From: George Swietlik [REDACTED]
Sent: 05 March 2026 15:18
To: Silvie Steiningerova <Silvie.Steiningerova@arun.gov.uk>
Cc: Planning <Planning@arun.gov.uk>
Subject: K/1/26/HH Retrospective Application

REF: **comments relating to application** K/1/26/HH **have been registered to reference is** OWPC81771

Application No: K/29/23/PL
Site Address: Panorama Golden Acre Kingston BN16 1QP
Description of works: Proposed roof extension and reorientation of roof position on single storey extension and alterations to fenestration.

EXISTING SECTION OF BALCONY 1:50

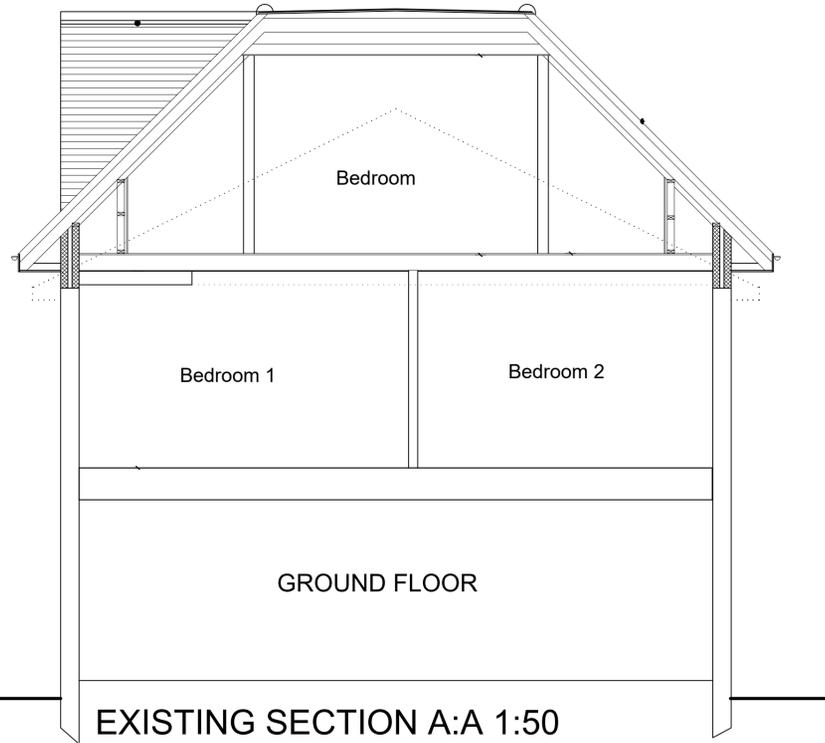
However, this application is incomplete as it avoids the subject matter of “the screening by Obscure Glass on the rear Balustrade/Balcony”. This still hasn’t been addressed and remains an issue and concern. This was raised in respect to K/29/23/PL. The need for a permanent and secure barrier between our property and the upstairs terrace remains. Especially, because of being overlooked and the possible invasion of noise created when the terrace is used. The distance between the end of the 1st floor terrace and the balcony of our main bedroom is certainly less than 25 metres. This requirement for screening as included in the prior conditions is a matter that requires closure however that space is occupied.

The drawings reveal a separate mounted screen behind a low balustrade wall. In the application no reference is made to this material change. (See attached DNG6, DNG7 and DNG8). The AH screen doesn't offer the same safeguard and longevity.

The statement made in DN6 indicates the removal of those low balustrade walls but DNG7 and DNG8 reveals otherwise. The fact that the proposed 'Artificial Hedge' is separate and does not form part of the balustrade wall calls into question the permanency of this change. The need for a permanent and secure barrier between our property and the upstairs terrace is a matter of concern. Especially, because of being overlooked and the possible invasion of noise created when the terrace is used. The distance between the end of the 1st floor terrace and the balcony of our main bedroom is certainly a matter of concern for us whoever occupies that space.
